WEST SUSSEX COUNTY COUNCIL CONSULTATION

TO:	Arun District Council FAO: Anita Gardner
FROM:	WSCC - Highways Authority
DATE:	11 July 2019
LOCATION:	7 Alleyne Way Bognor Regis PO22 6JZ
SUBJECT:	M/53/19/PL Demolition & erection of 1 No. dwelling.
DATE OF SITE VISIT:	
RECOMMENDATION:	Advice
S106 CONTRIBUTION TOTAL:

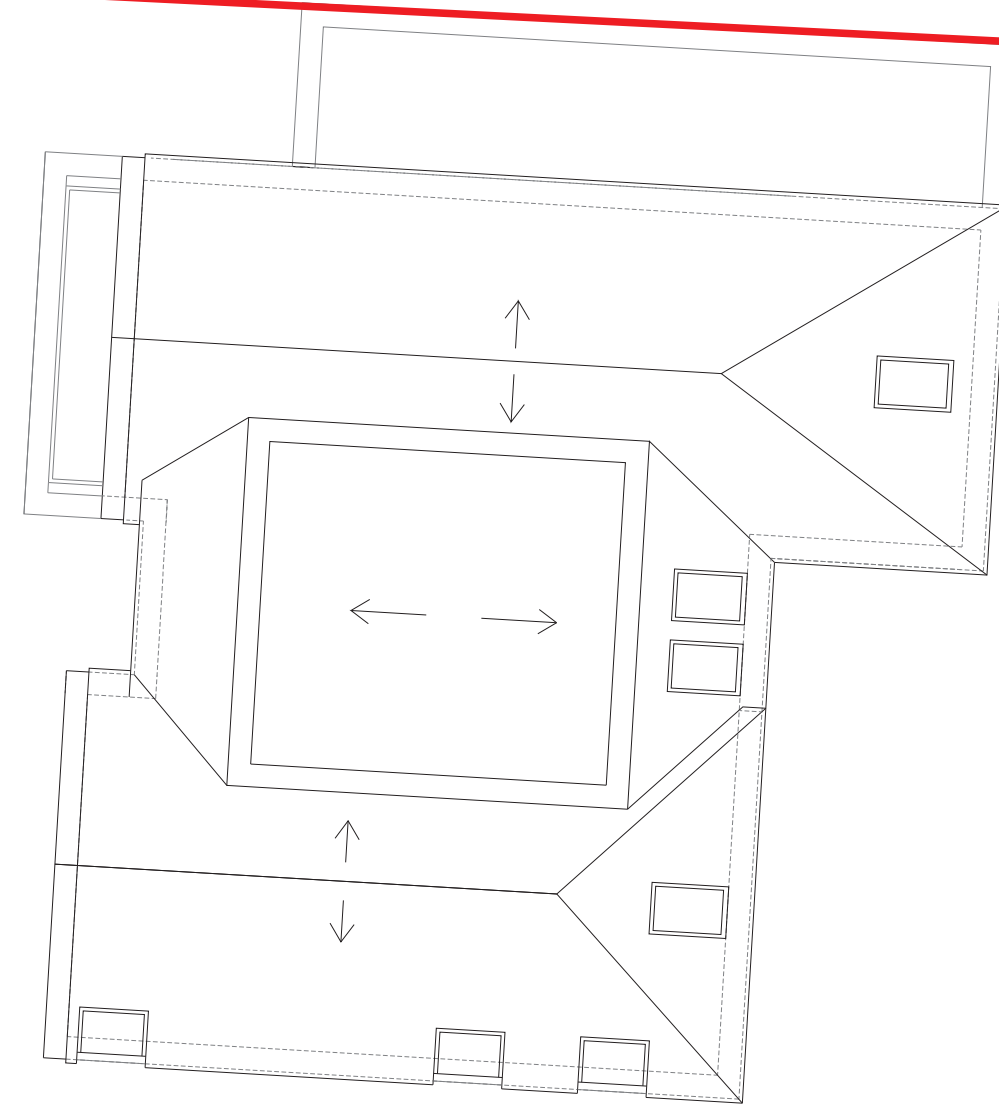
The proposed plans do not show any type of cycle parking provision, as per the WSCC Sustainability policy we wish to see this implemented in the form of lockable covered storage; this may be secured via condition if approved.

No part of the development shall be first occupied until covered and secure cycle parking spaces have been provided in accordance with plans and details to be submitted to and approved by the Local Planning Authority.
